Ribble Valley Borough Council
Housing & Development Control

Application no: **3/2023/0055**

Address: **53 to 57 Berry Lane Longridge PR3 3NH**

Proposal: **Change of use of Unit 2 from retail unit (Class E) to a Hot Food Takeaway (Sui Generis) with installation of extraction equipment. Shop front alterations to units 1 and 2.**

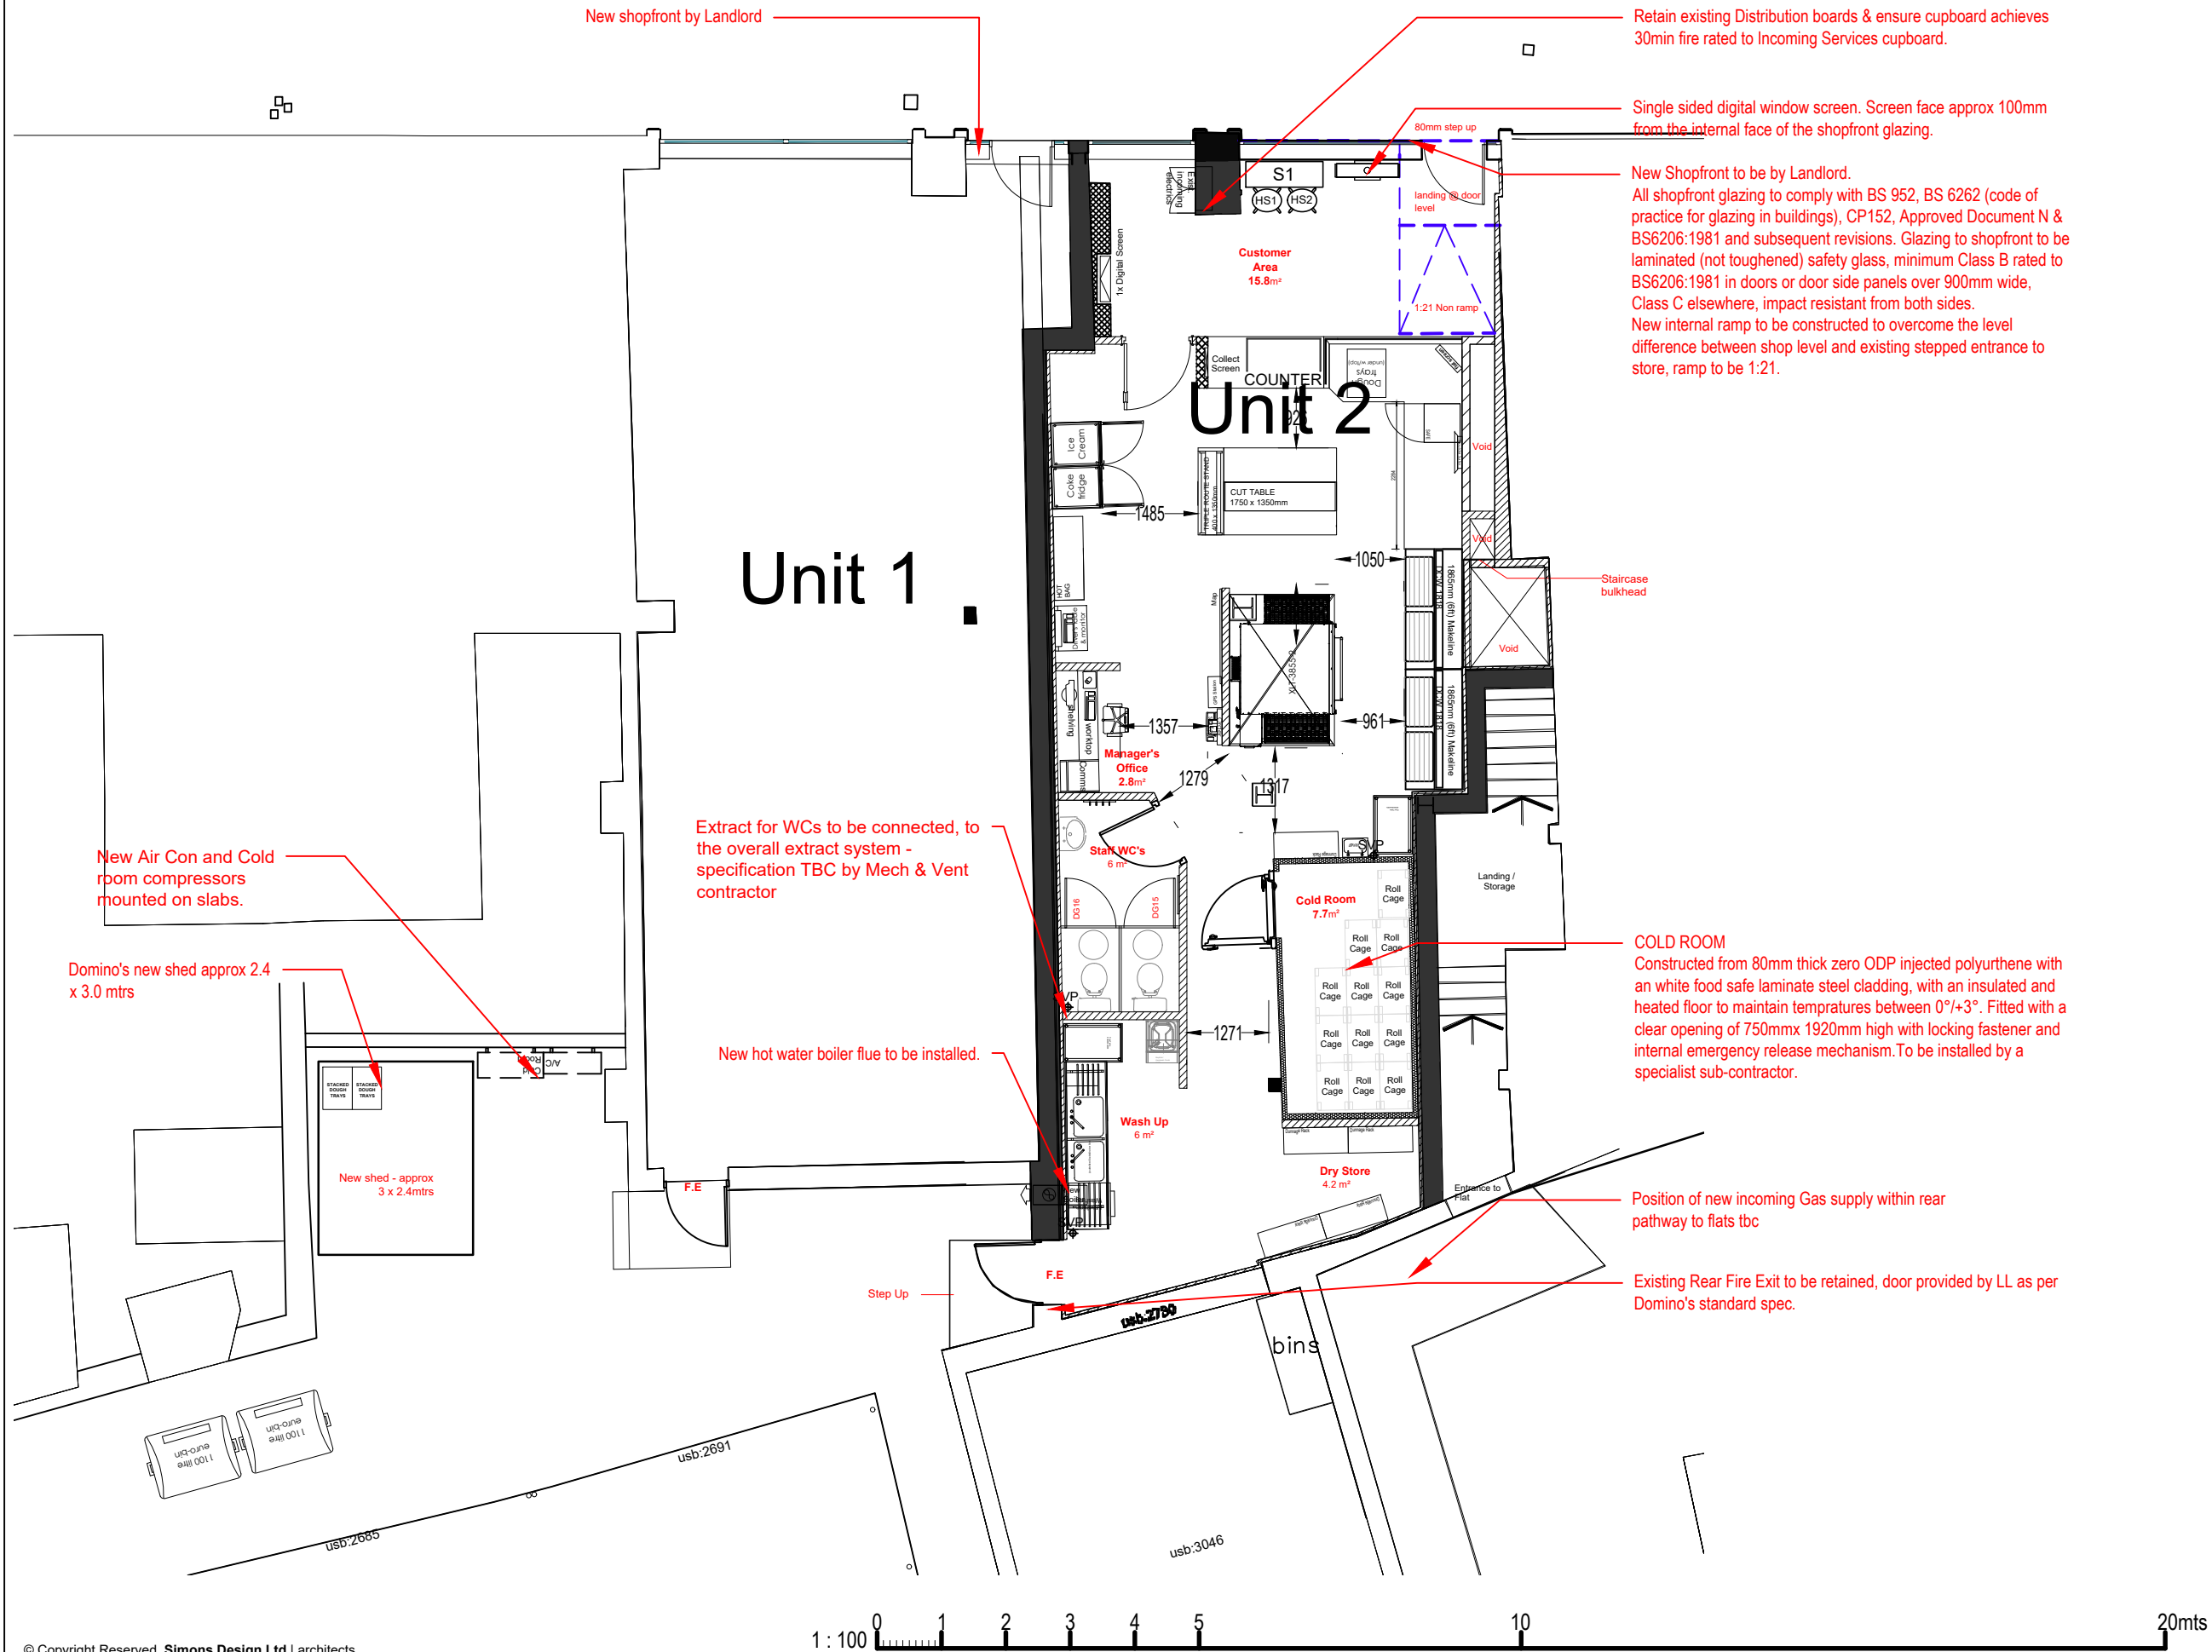
While the site will not provide any car parking spaces, which will be discussed in further detail in the next section, the site will be serviced at the rear of the unit which is located off Warwick Street, an unclassified road subject to a 20mph speed limit.

Before the LHA can comment on the suitability of Warwick Street as a servicing location for the proposal, the LHA require a delivery and service plan to be submitted. In the plan, details should emerge regarding the type of vehicles which will service the site, the frequency and the expected time for deliveries.

The LHA make the Agent aware that Warwick Street serves numerous commercial units as well as a number of dwellings, which do not have access to off-street car parking facilities. Therefore, this means that cars park on-street on both sides of the adopted highway. As a result of this, the LHA are concerned that should a large delivery vehicle service the proposal from this location then Warwick Street is likely to be unsuitable.

The LHA require a delivery and service plan to be submitted to support the application. This is because the LHA have concerns regarding the site being serviced from Warwick Street.
